From: Tom Errico <thomas.errico@tylin.com>
To: Jean Fraser <JF@portlandmaine.gov>
CC: David Margolis-Pineo <DMP@portlandmaine.gov>, Katherine Earley <KAS@port...>
Date: 6/26/2015 10:38 AM
Subject: Jewish Community Center - Final Traffic Comments

Jean - I have reviewed the revised application materials and the following represents a status update on my previous comments.

SITE PLAN

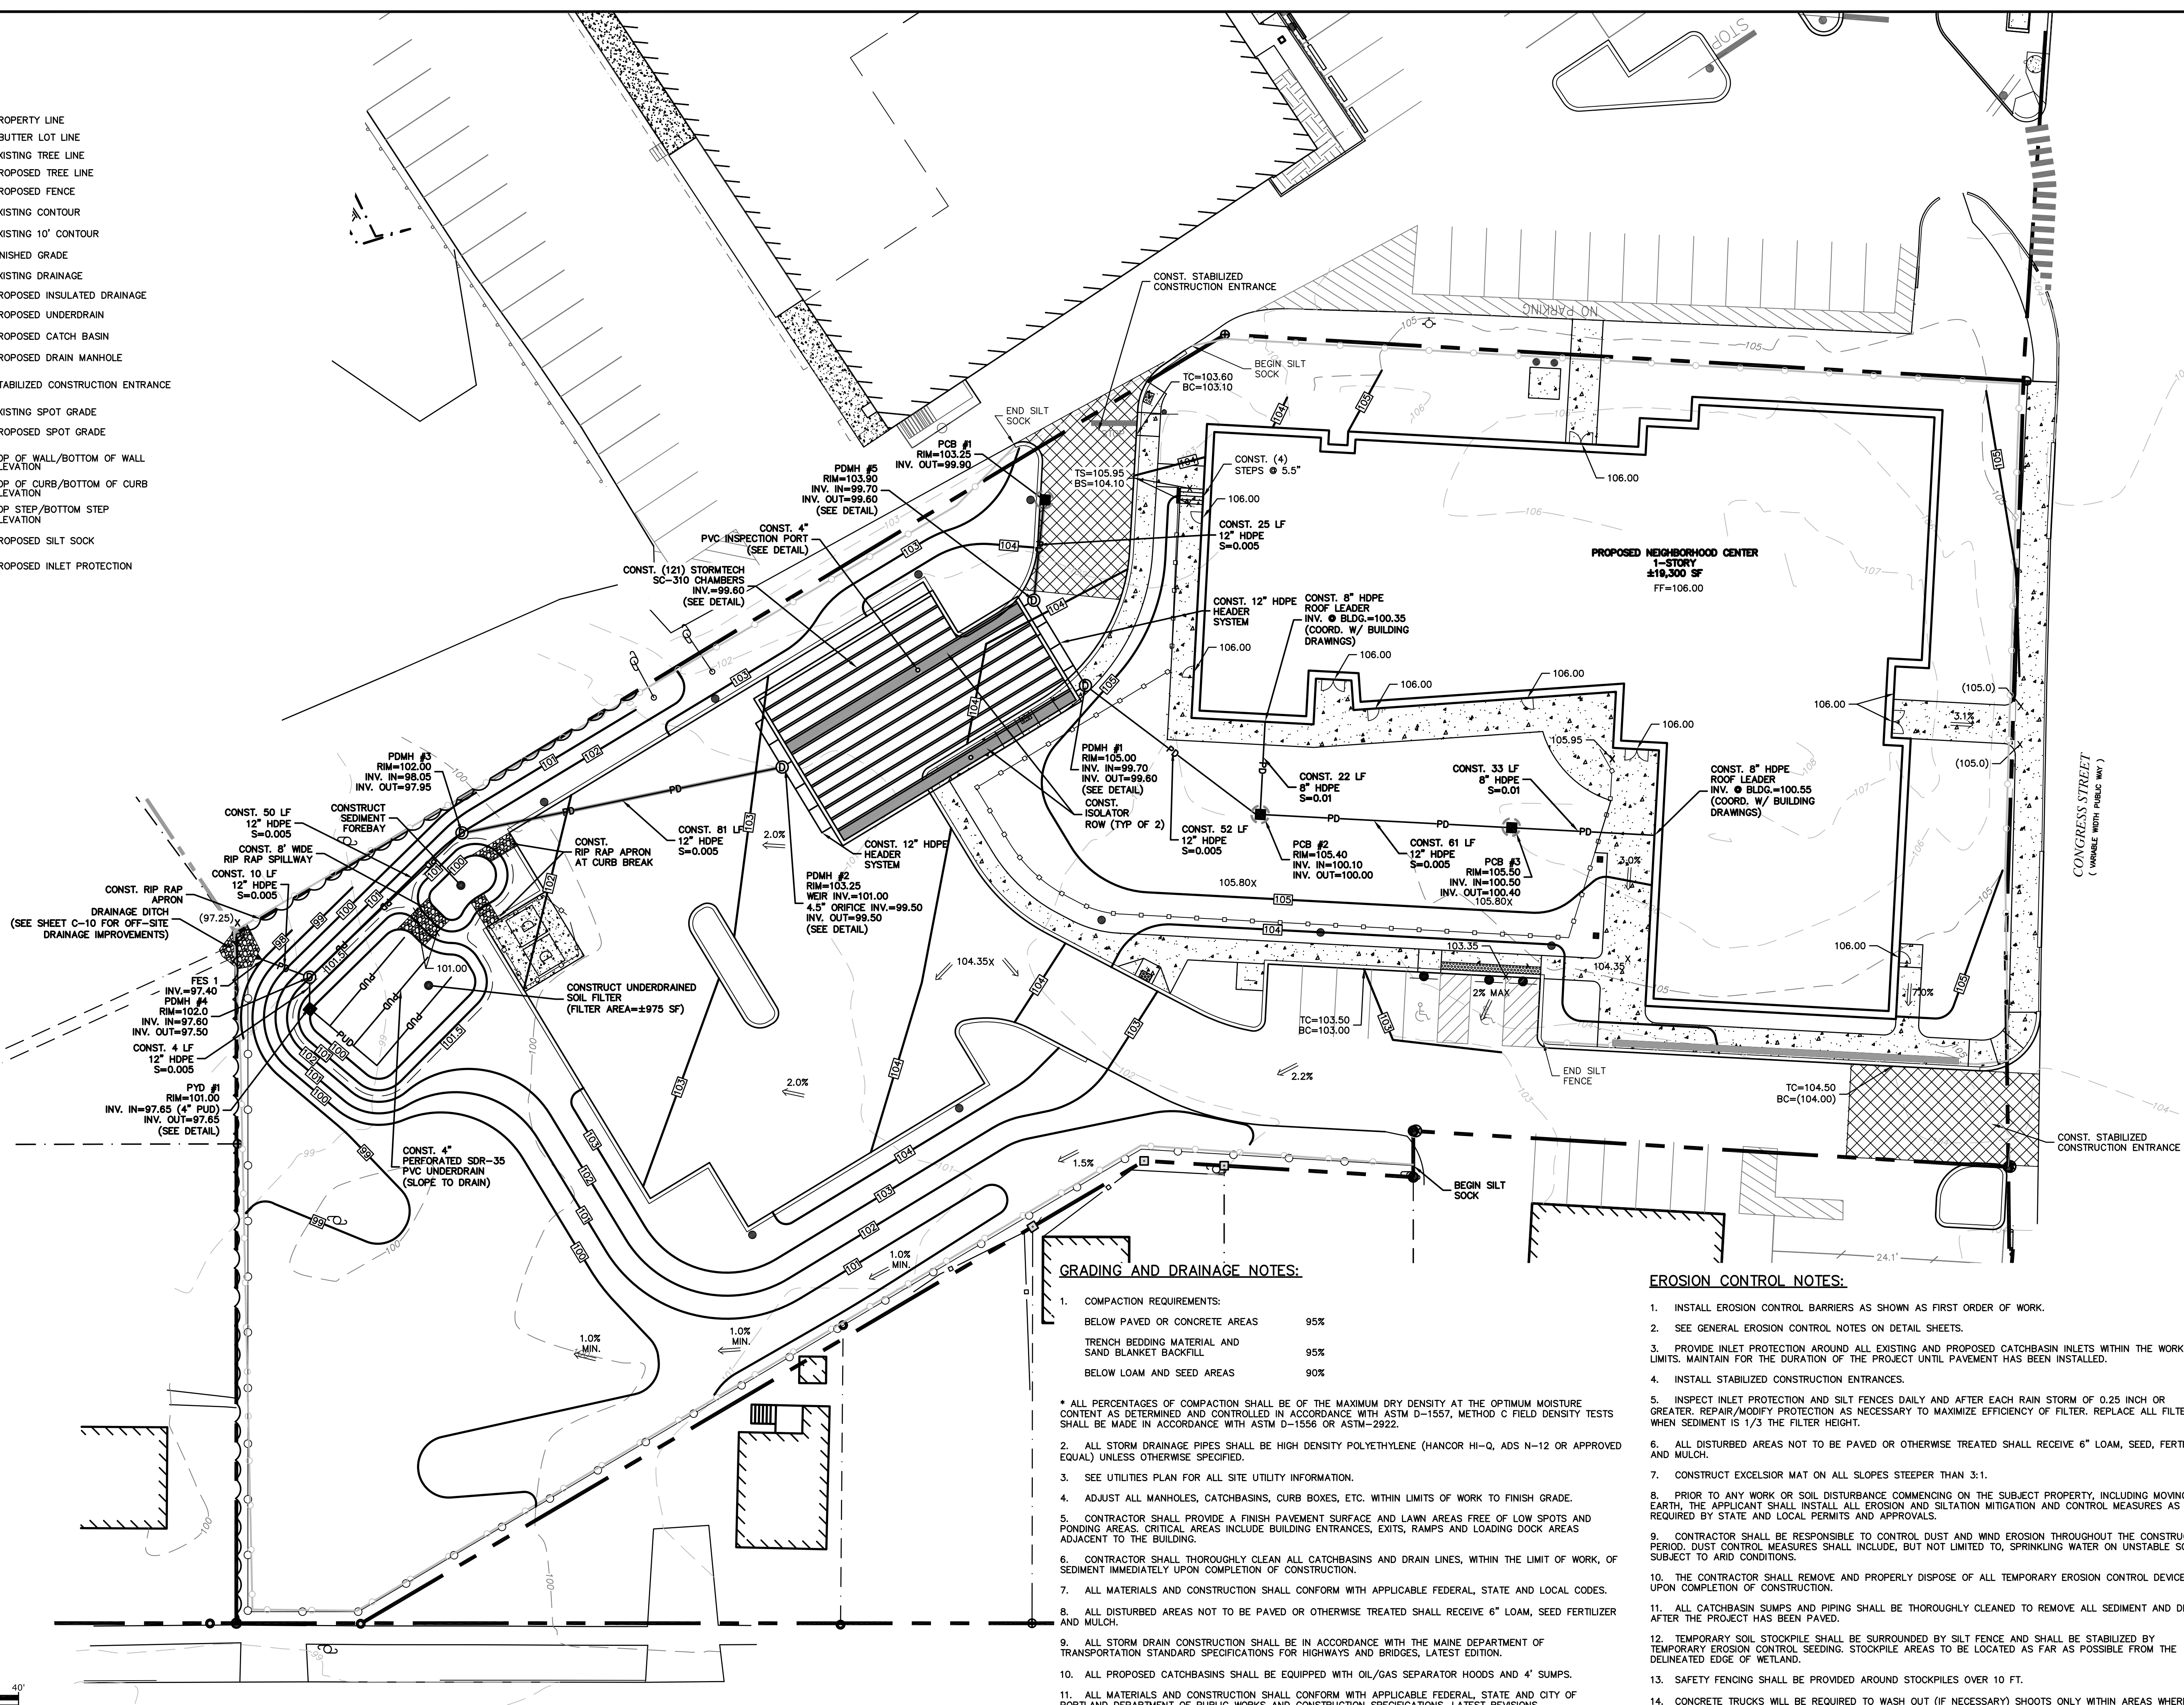
* The driveway entering the site from Congress Street is noted as having a width of 22.7 feet. This width (in the area where parking maneuvers occur) does not meet City standards and thus a formal waiver should be requested by the applicant.

* I would suggest a tip-down curb entering the driveway on Congress Street, as currently provided.

Status: The curb ramp layout should be revised so that the ramp flare does not impact accessibility along the sidewalk route. Having a tip-down design will help to address this issue.

* The applicant shall consider the formal delineation of the driveway along the medical office property boundary, when entering from Congress Street.
Status: The site plan has been revised and I find conditions to be acceptable.

* The pick-up and drop-off of daycare and others will need to be carefully managed. Accordingly, the applicant should provide specific details on how this process will take place. This should include what building entrances will be used, sidewalk facilities between parking spaces and the noted entrance, etc. I would note that the pick-up/drop-off program must be managed such that vehicles are not parking along the driveway off Congress Street.

Status: I find the proposed driveway width to be acceptable given that most vehicles will be passenger cars and that a secondary driveway via the Westgate Shopping Center will be provided. I support this waiver request.

Status: I have reviewed existing JCA activity at their current Portland site and I have recommended that a barrier be constructed that prevents pedestrians from accessing the building entrance near Congress Street. The applicant has revised the site plan to include a 18" sitting wall along the curb. While the height of the wall is mountable by pedestrians, I do believe the physical presence of the wall will deter drop-off and pick-up activity near Congress Street. Accordingly, I find conditions to be acceptable.
